**Subject:** FAO Steffan Jones -Our Client :Mr DR & Mrs EM Owen ,Tyddyn Bartley, Llanefydd,Denbigh  
-Proposed North Wales Wind Farms Scheme Our Ref: NWW.Owe.R/2/EW SUBJECT TO CONTRACT

Further to our telephone conversation of earlier today , in respect of Scottish Power's Option A proposal (given that we understand Option B has not yet been submitted for consideration), we confirm that our above mentioned client has asked that we request the Planning Inspectorate ,please, to visit the subject affected land in their ownership so as to be in a position to comprehend the requests made for the following modifications to the scheme proposal (in order to mitigate a lasting impact) :

Appendix 1 – Hedgerow Planting Regime

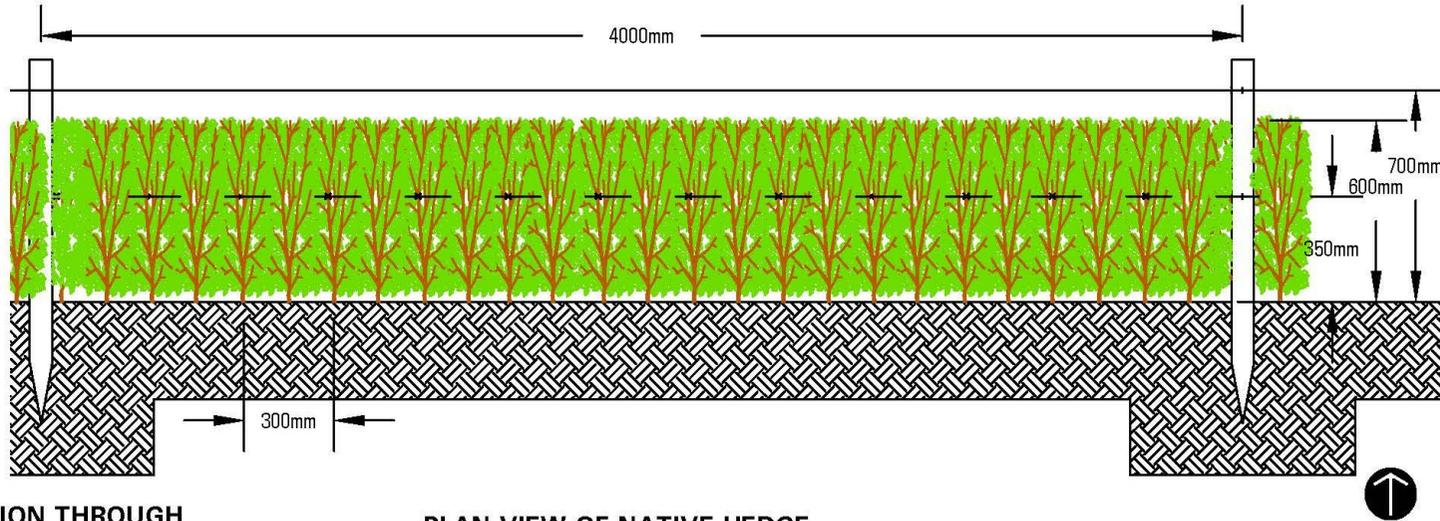
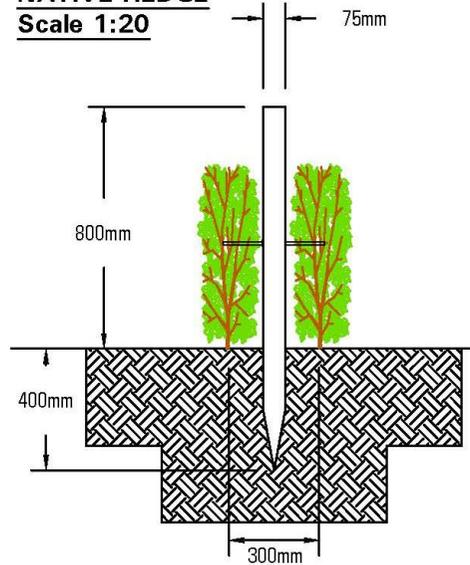
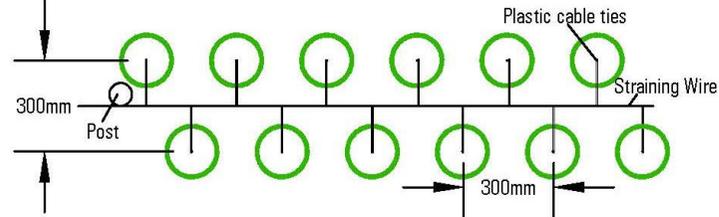
- 1.That proposed Poles 179 (together with stays) could be re-located within the neighbouring wooded parcel to the east (in the direction of Poles 178) to reduce the significant impact on productive agricultural land (and interference with the roadside gateway to the parcel ).
- 2.Also that no trees are to be planted on the roadside perimeters (appertaining to our client's property –including the subject field and to the south of Tyddyn Bartley driveway entrance) owing to concerns on highway safety and the future cost of maintenance [albeit hedge plants within gapped areas, along the boundary (excluding, of course, the gated access facility to the agricultural land ) would be permitted].
